24th October 2023

Ref : 23/02471/F - Erection of 14 two storey dwellings and upgrading of existing access onto the Heyford Road, together with garaging and parking, footpath link, the removal and re-instatement of a section of existing wall and its repair along the Heyford Road frontage, and landscaping and all enabling development; OS Parcel 0622 South Of Jersey Cottages And East Of Heyford Road, Kirtlington

Margie Hoffnung
Conservation Officer

Title : **Site Access Visibility Splays**

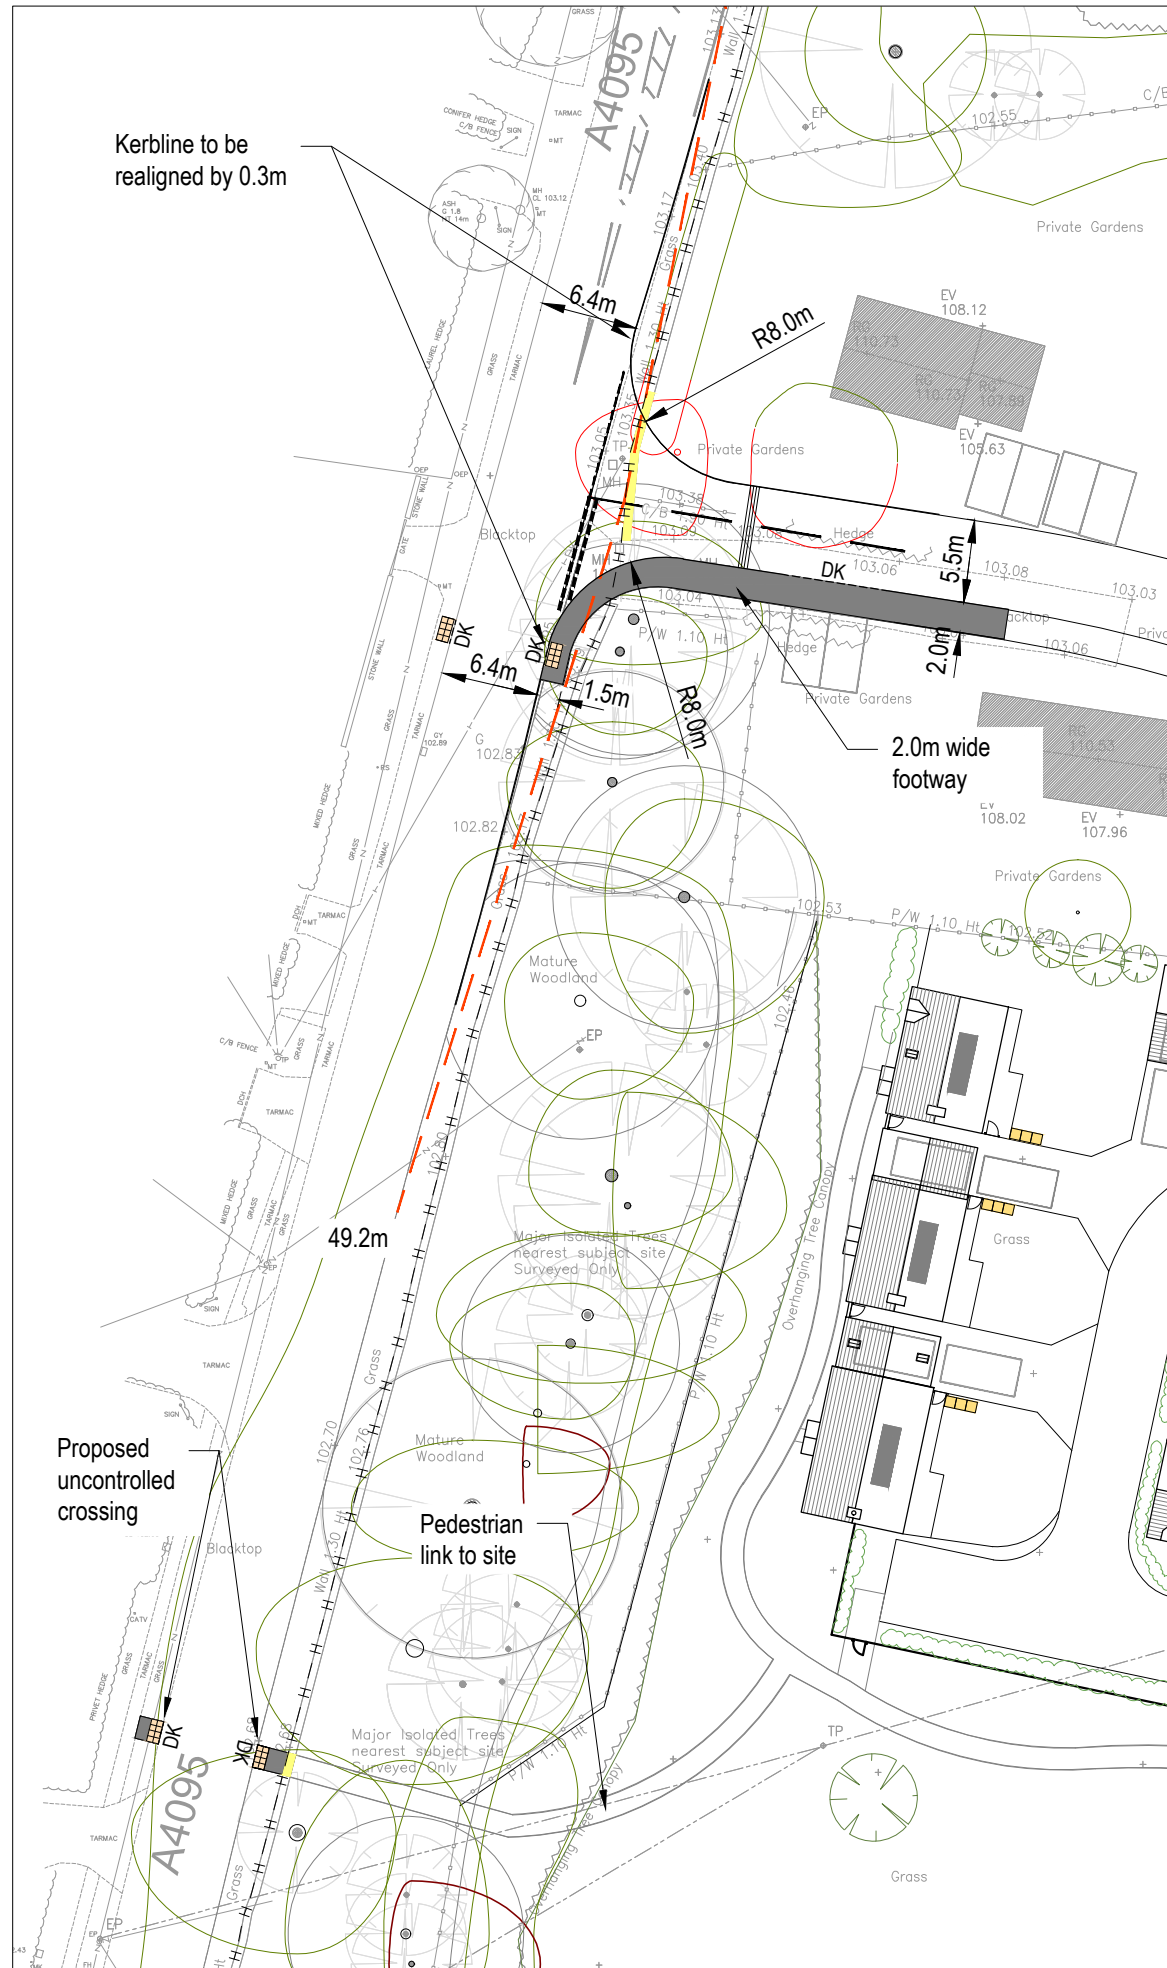
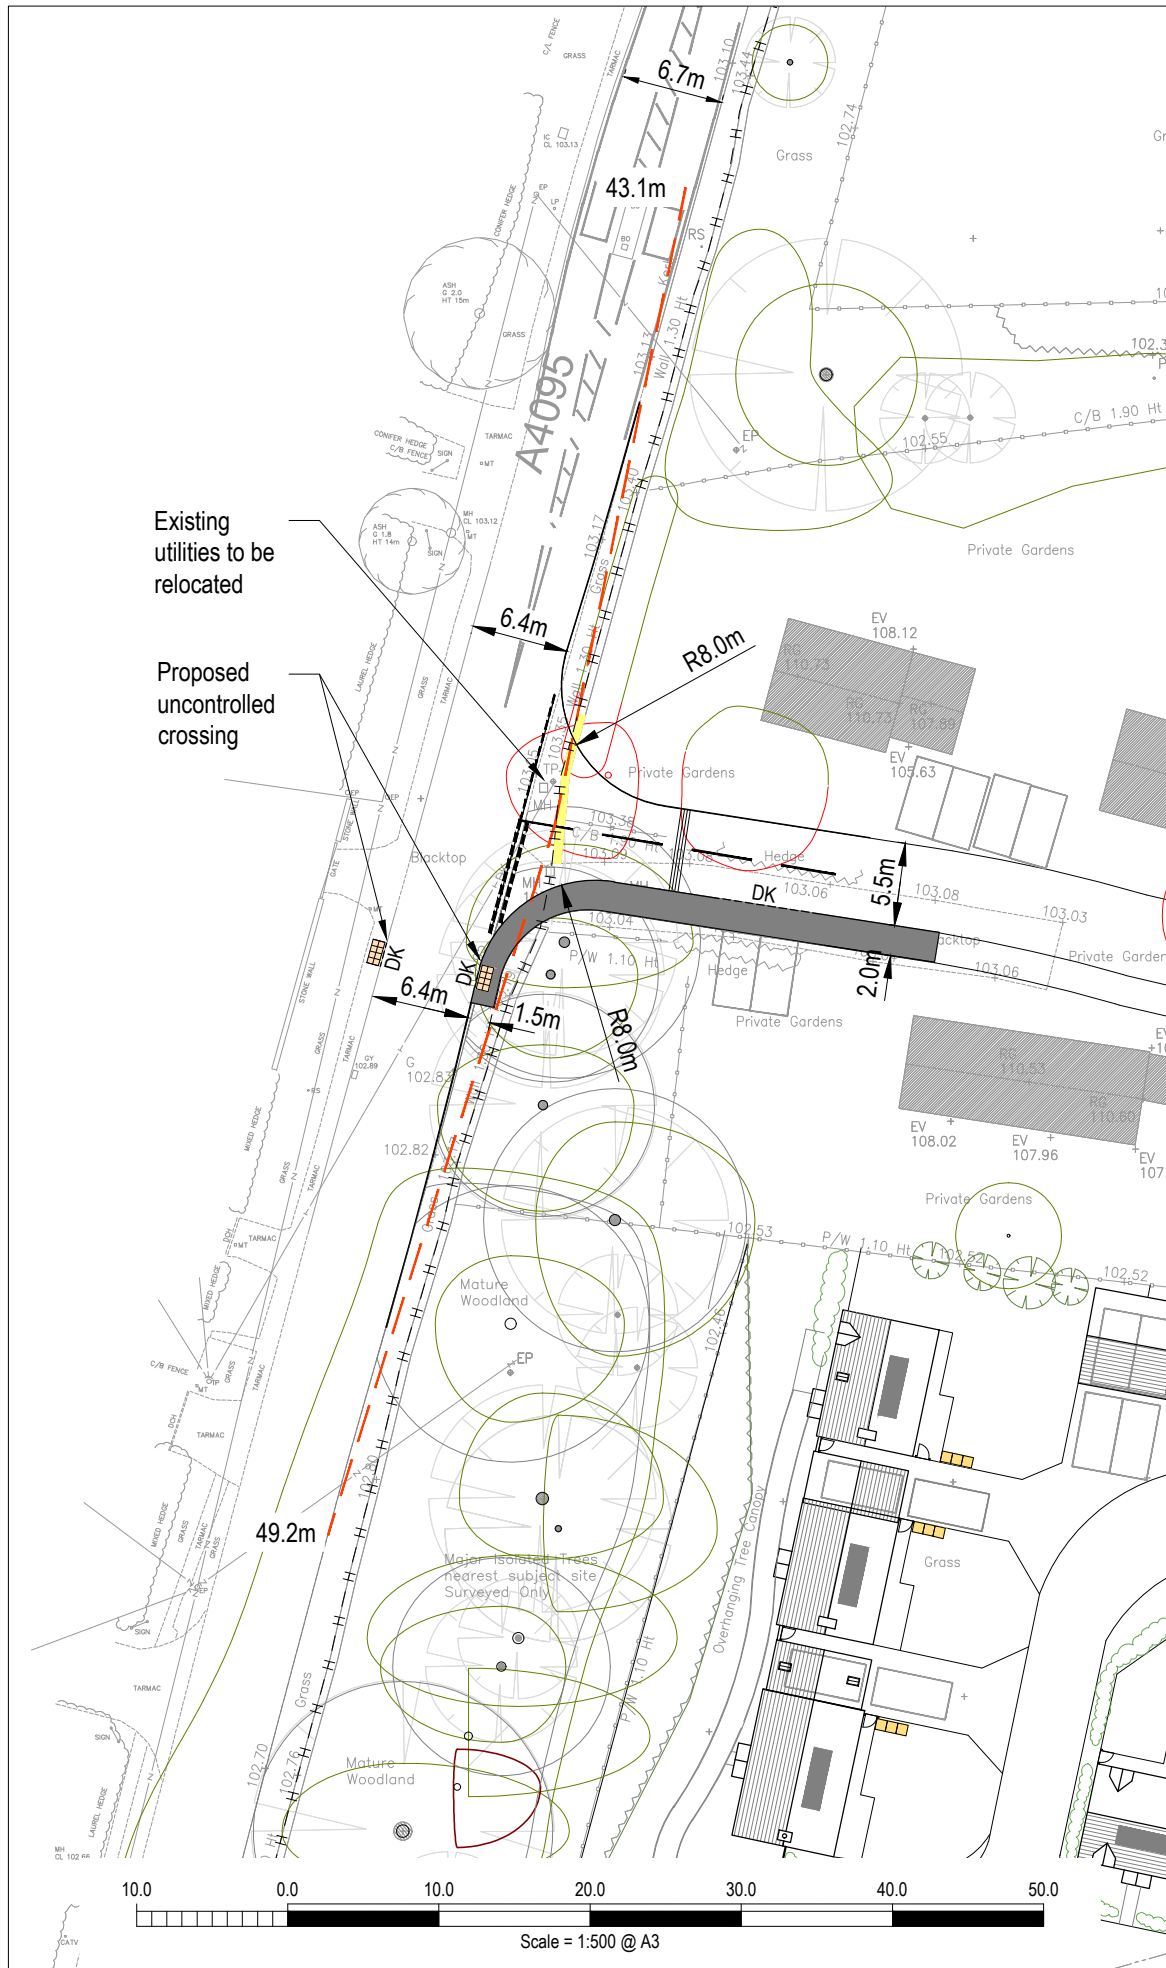
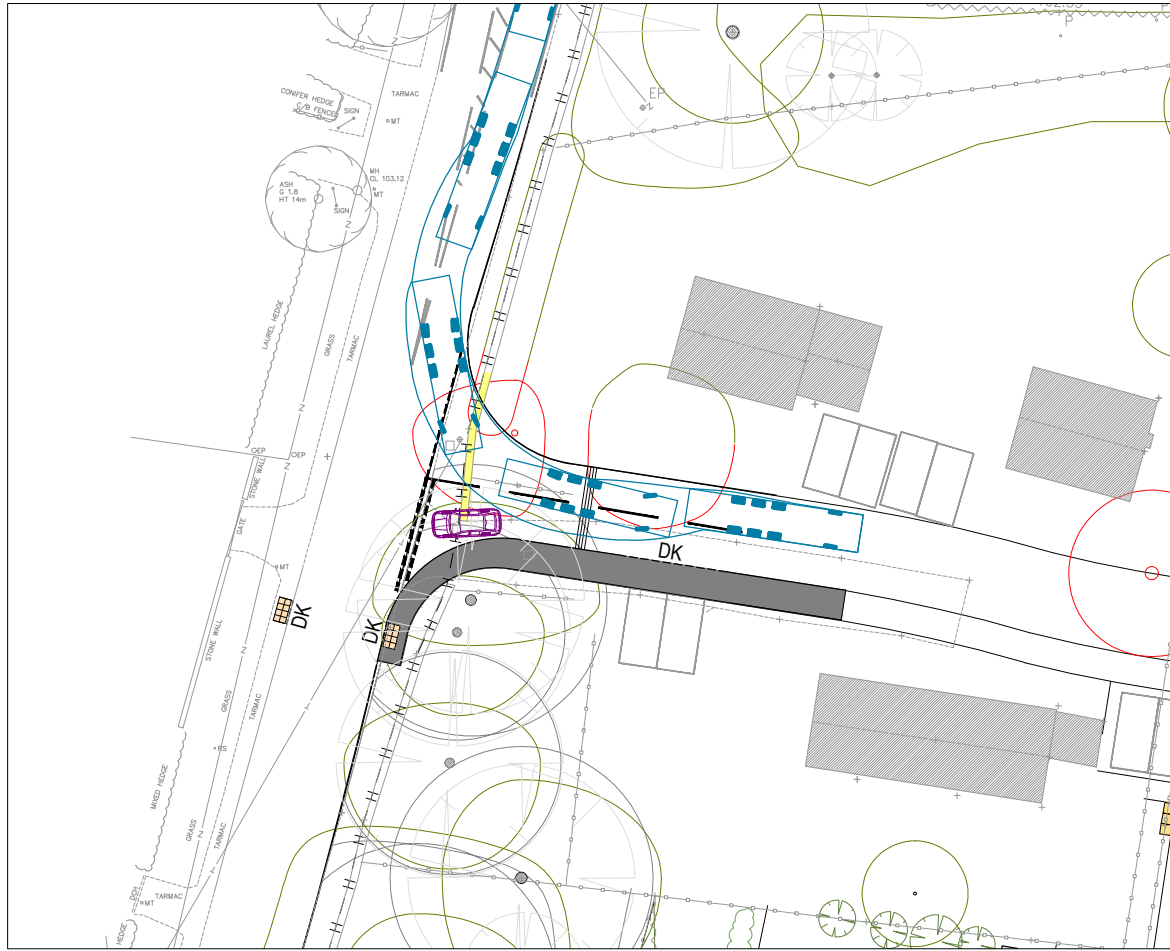
The applicant has indicated a pedestrian gate in the wall giving access into the site. The breaching of the wall, albeit limited, we consider has an adverse impact on the character and appearance of the Conservation Area and the setting of the Park.
